A57 Link Roads

TR010034

8.3 DRAFT STATEMENT OF COMMON GROUND WITH HIGH PEAK BOROUGH COUNCIL

Version	Date	Status of Version
Rev 2.0	January 2022	Deadline 2
Rev 1.0	June 2021	DCO Application

**6.4 Environmental Statement
Figure 5.1 Air Quality Constraints Map**

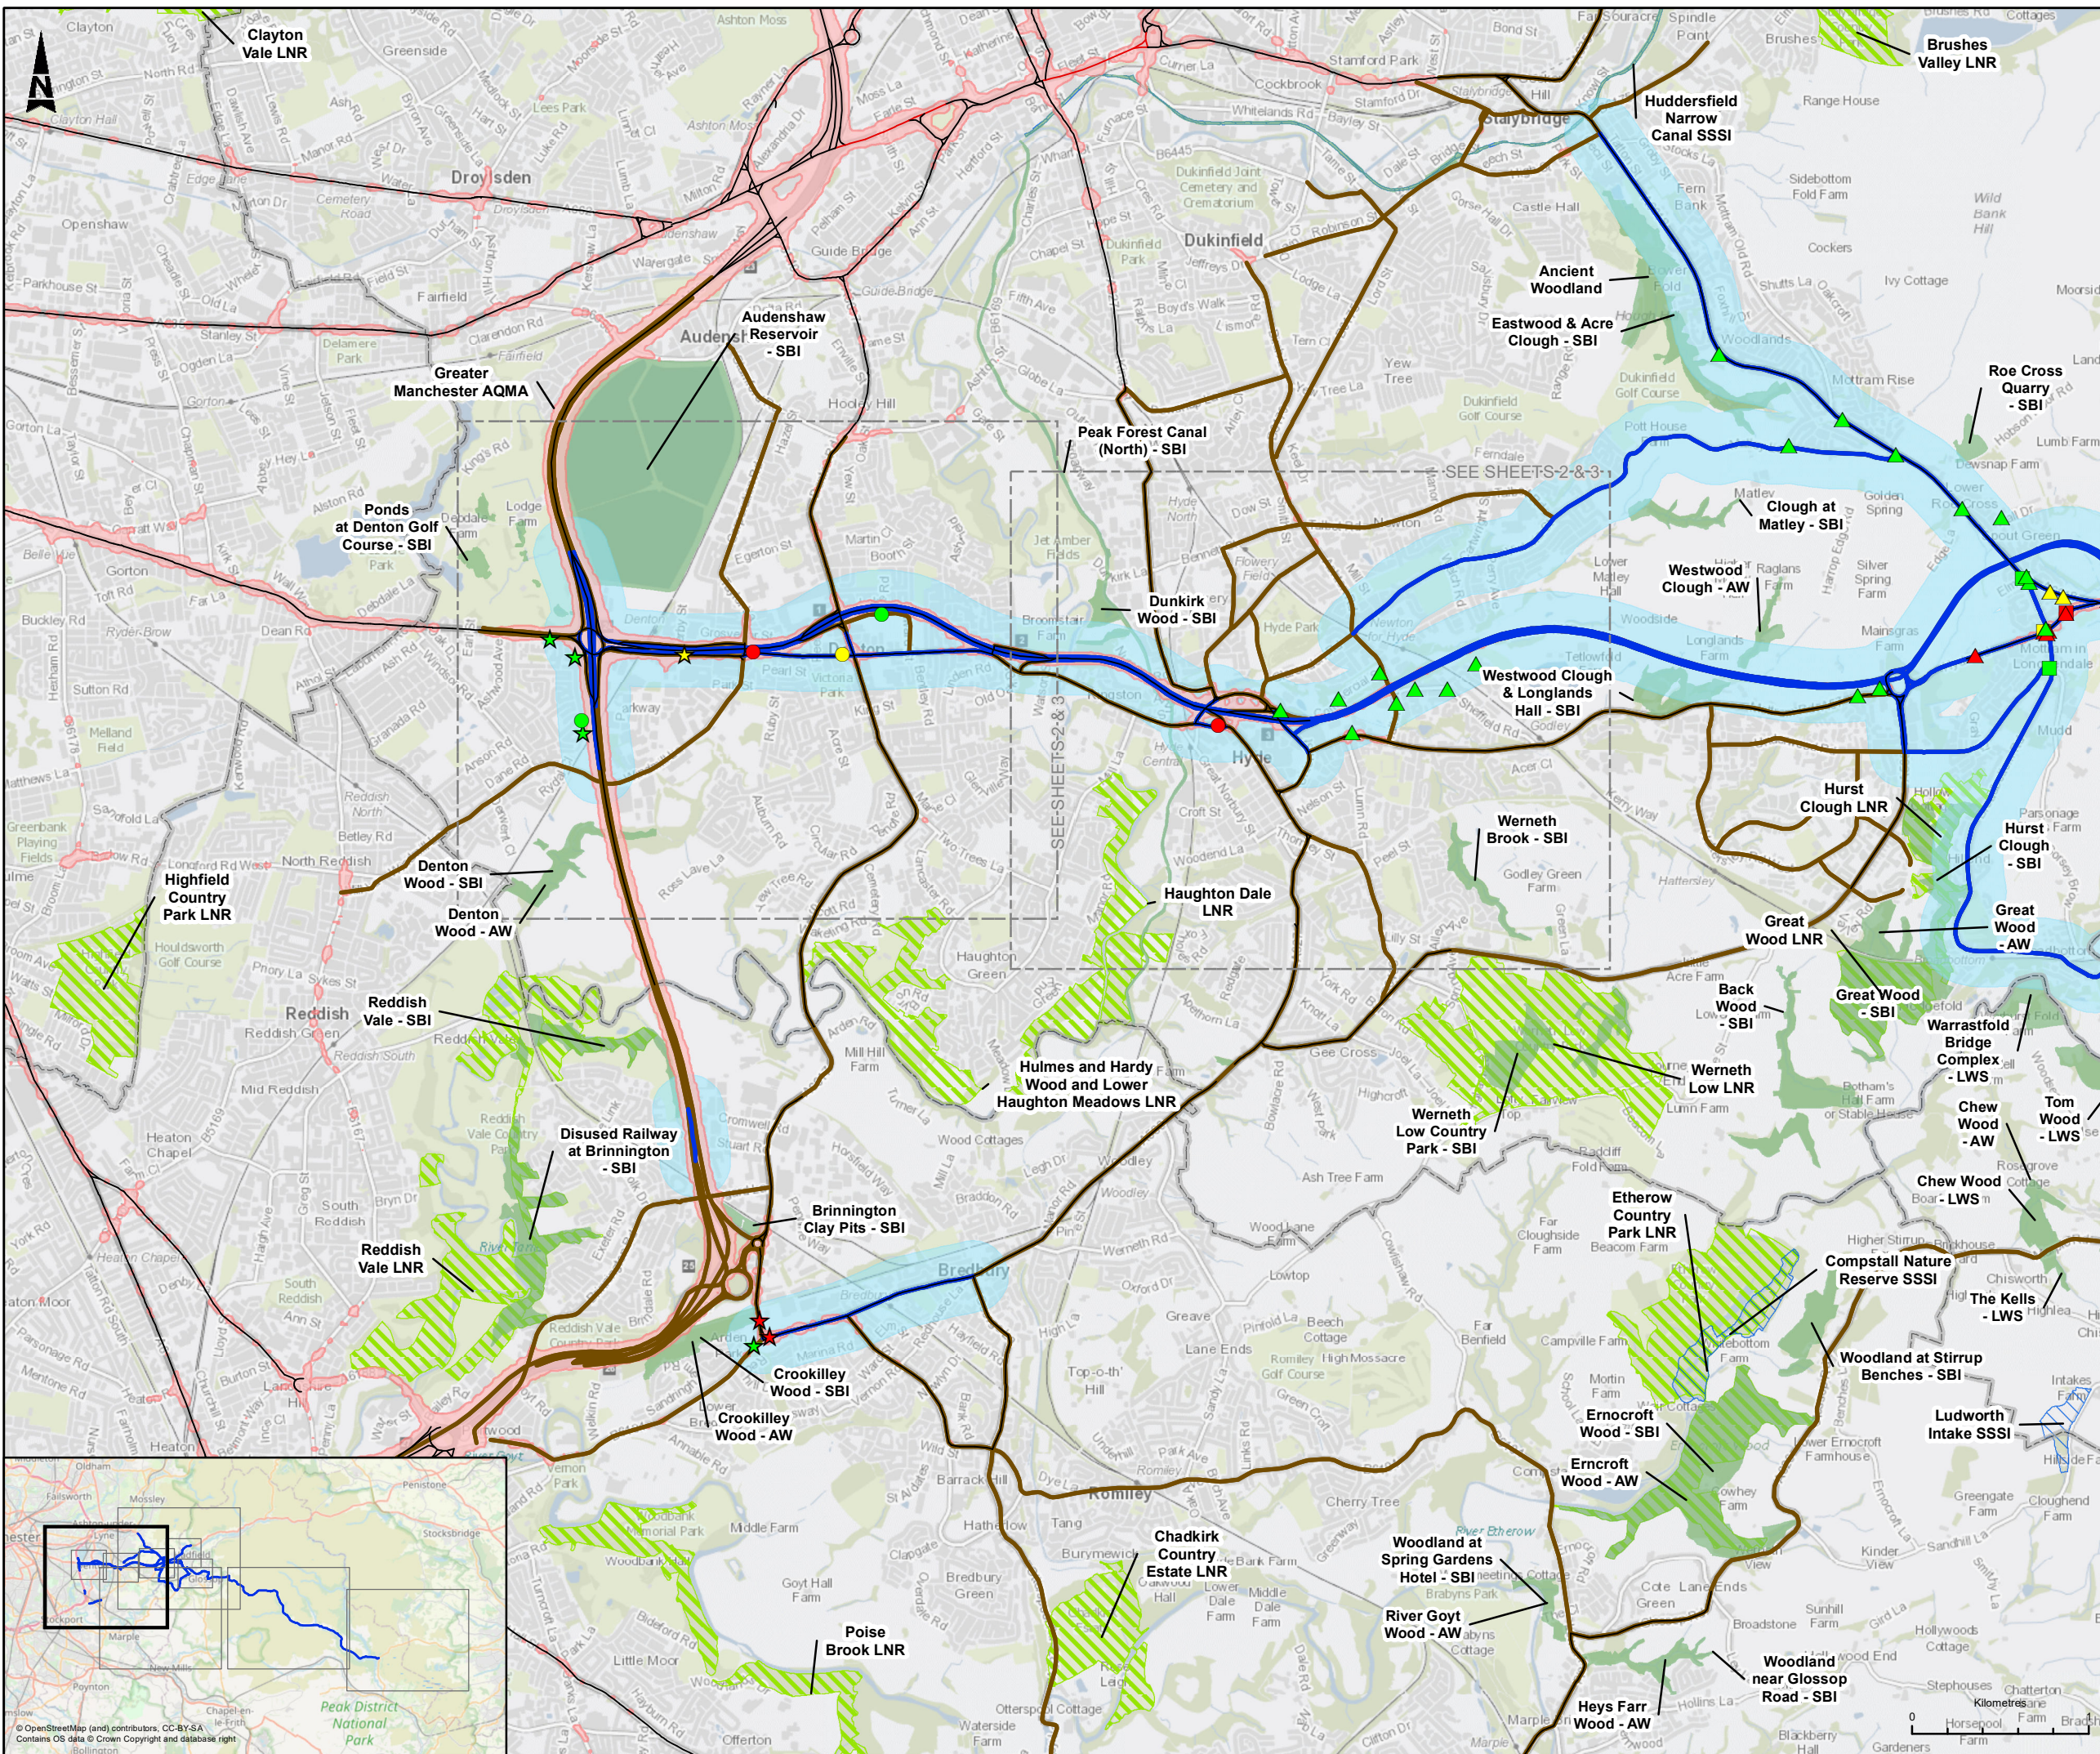
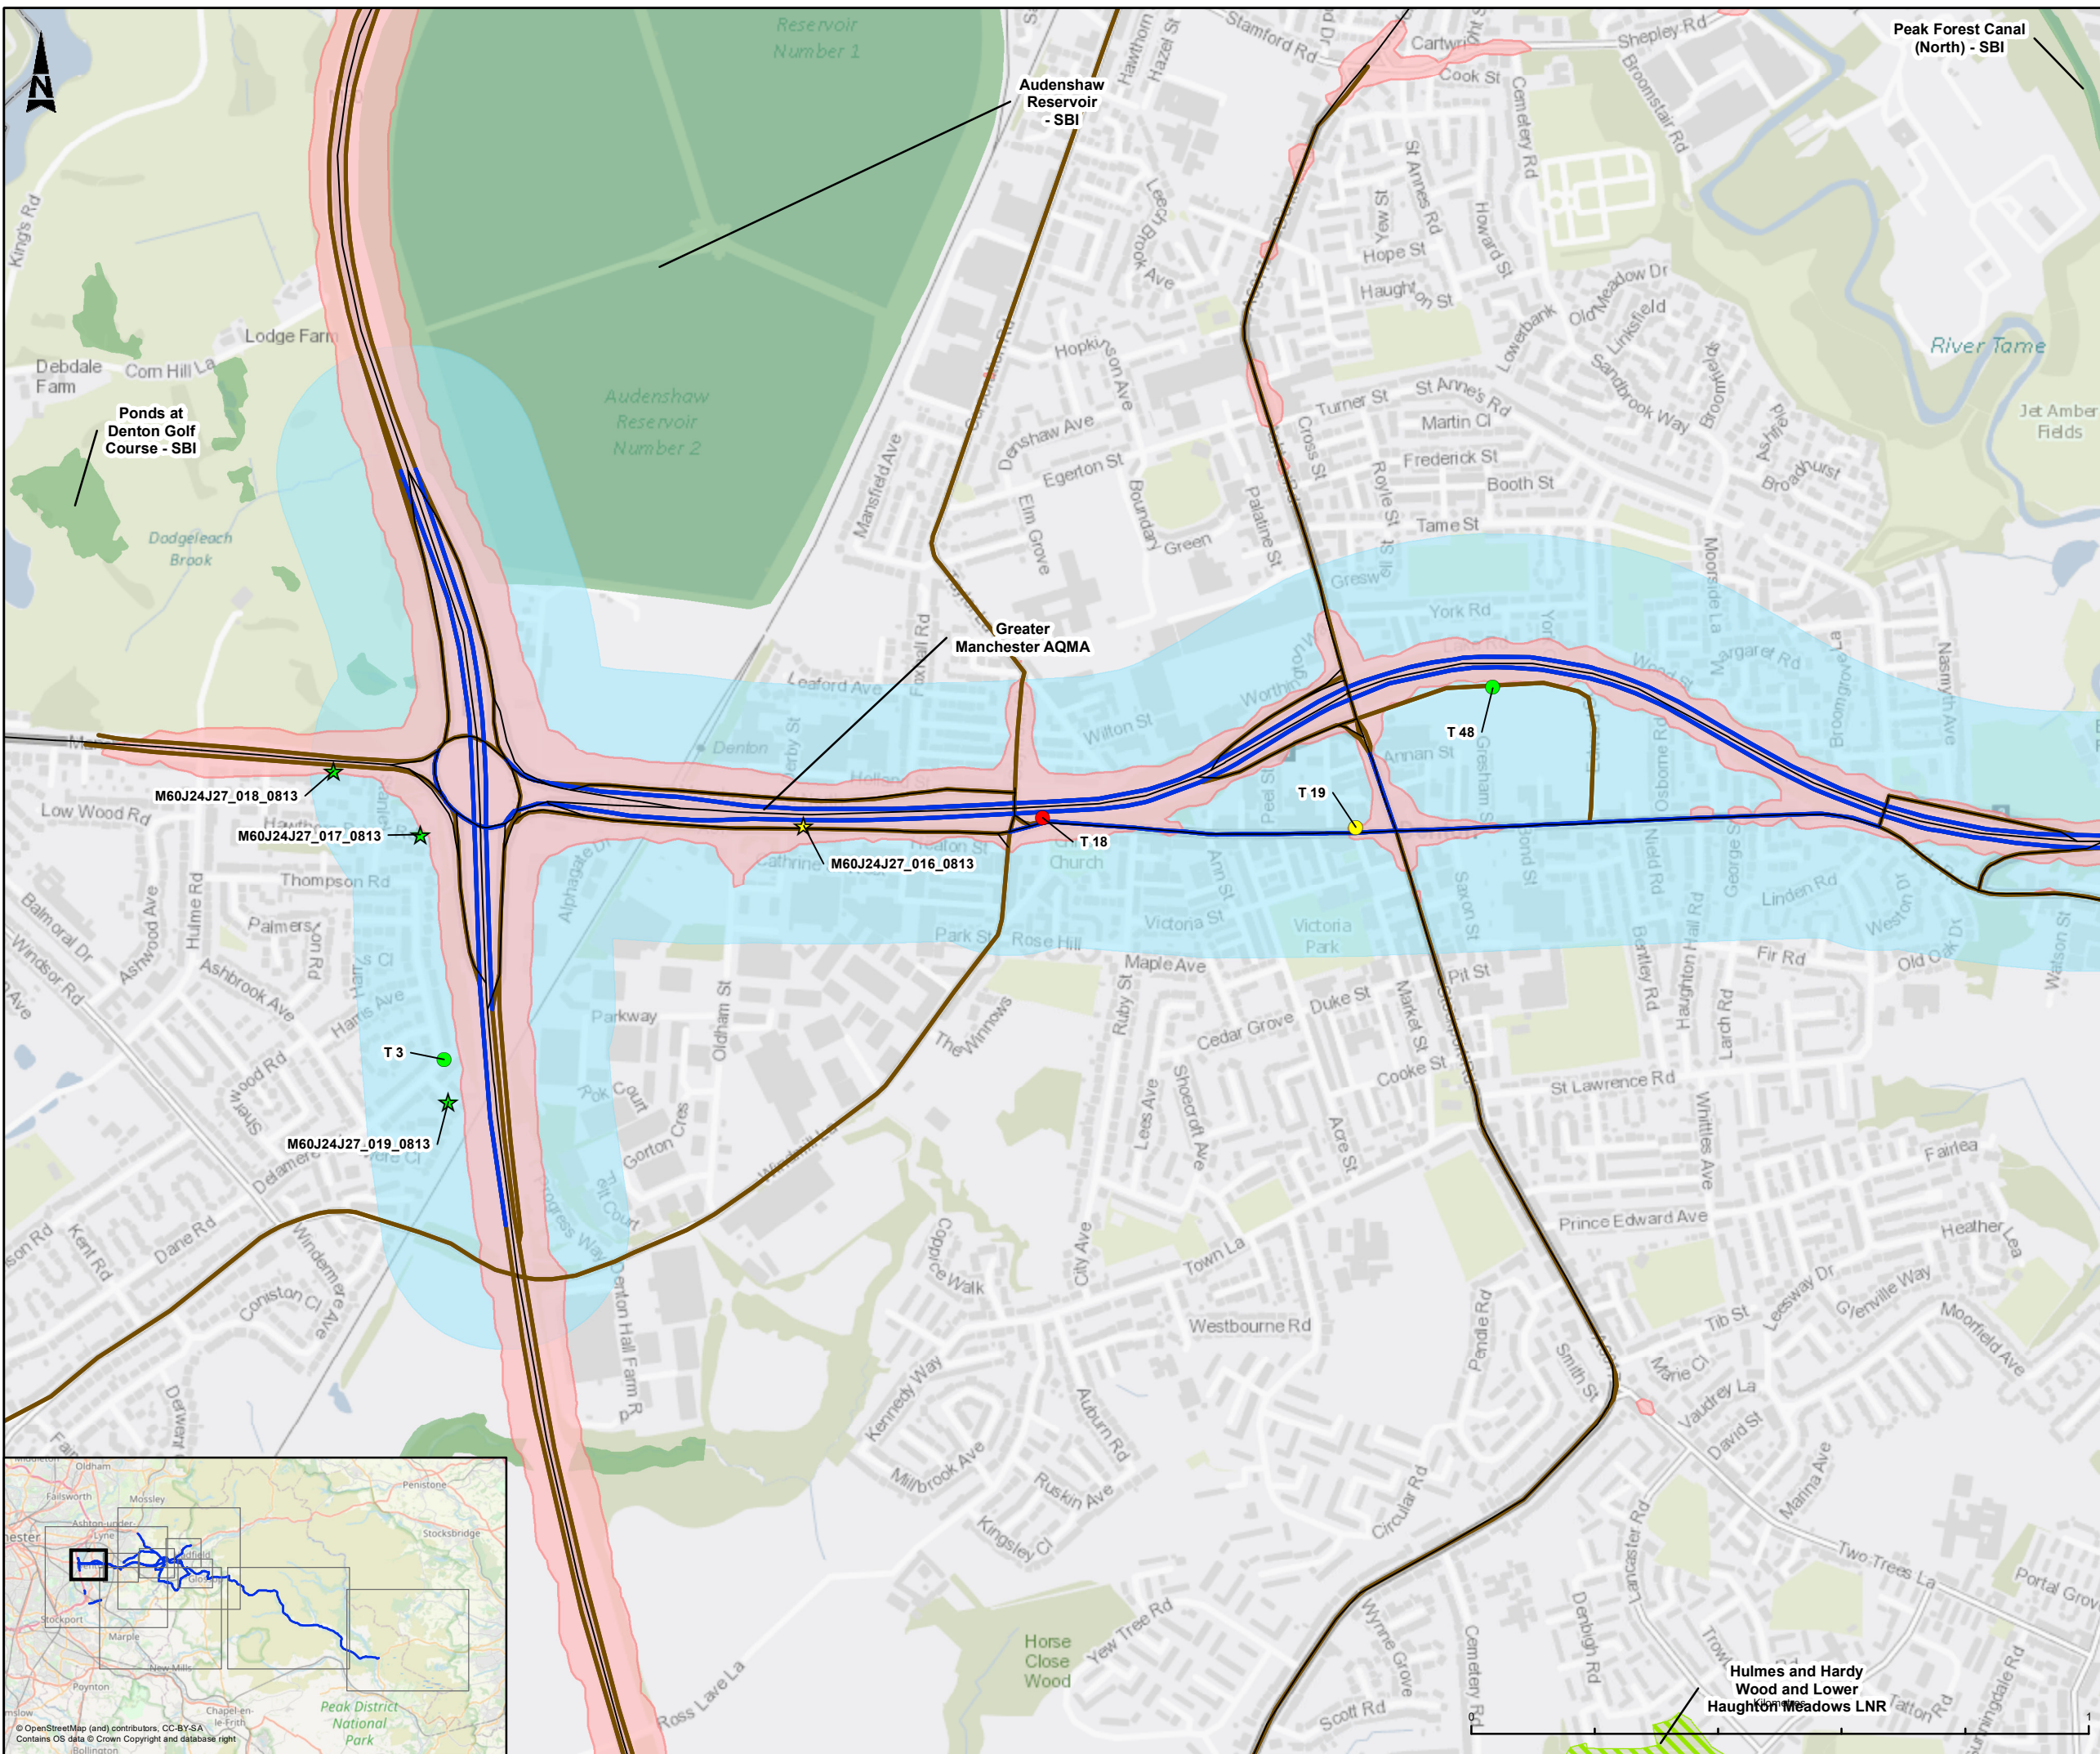
SoCG Ref. Number	Relevant examination document	Relevant Issue	HPBC Comment	National Highways response	Status
3. Environmental Statement and DCO Requirements					
3.1	Environmental Statement (ES)	Air Quality Methodology	The Consultee stated that air quality is a major concern. Since the last public consultation on the scheme in 2018, HPBC has designated Air Quality Management Areas (AQMAs) on sections of the A628 in Tintwistle and the A57	The Applicant's air quality assessment (in the ES [APP-061] has taken into consideration the AQMA designated since 2018 in Tintwistle and Dinting Vale. The air quality assessment has been	Under Discussion

SoCG Ref. Number	Relevant examination document	Relevant Issue	HPBC Comment	National Highways response	Status
	[APP-061]	AQMAs	at Dinting. Detailed assessment is required.	undertaken in accordance with DMRB LA105 with the air quality study area determined on the basis of traffic change criteria given this guidance.

3.2	Environmental Statement (ES) [APP-061]	Air Quality Methodology Dinting Vale	The Consultee questioned the air quality results at Dinting Vale.	The air quality assessment has been undertaken in accordance with DMRB LA105 with the air quality study area determined on the basis of traffic change criteria given this guidance. A detailed assessment of air quality has been undertaken for all areas where traffic changes are expected, which includes the Dinting Vale area. Full results will be reported in the Environmental Statement [APP-061].	Under Discussion
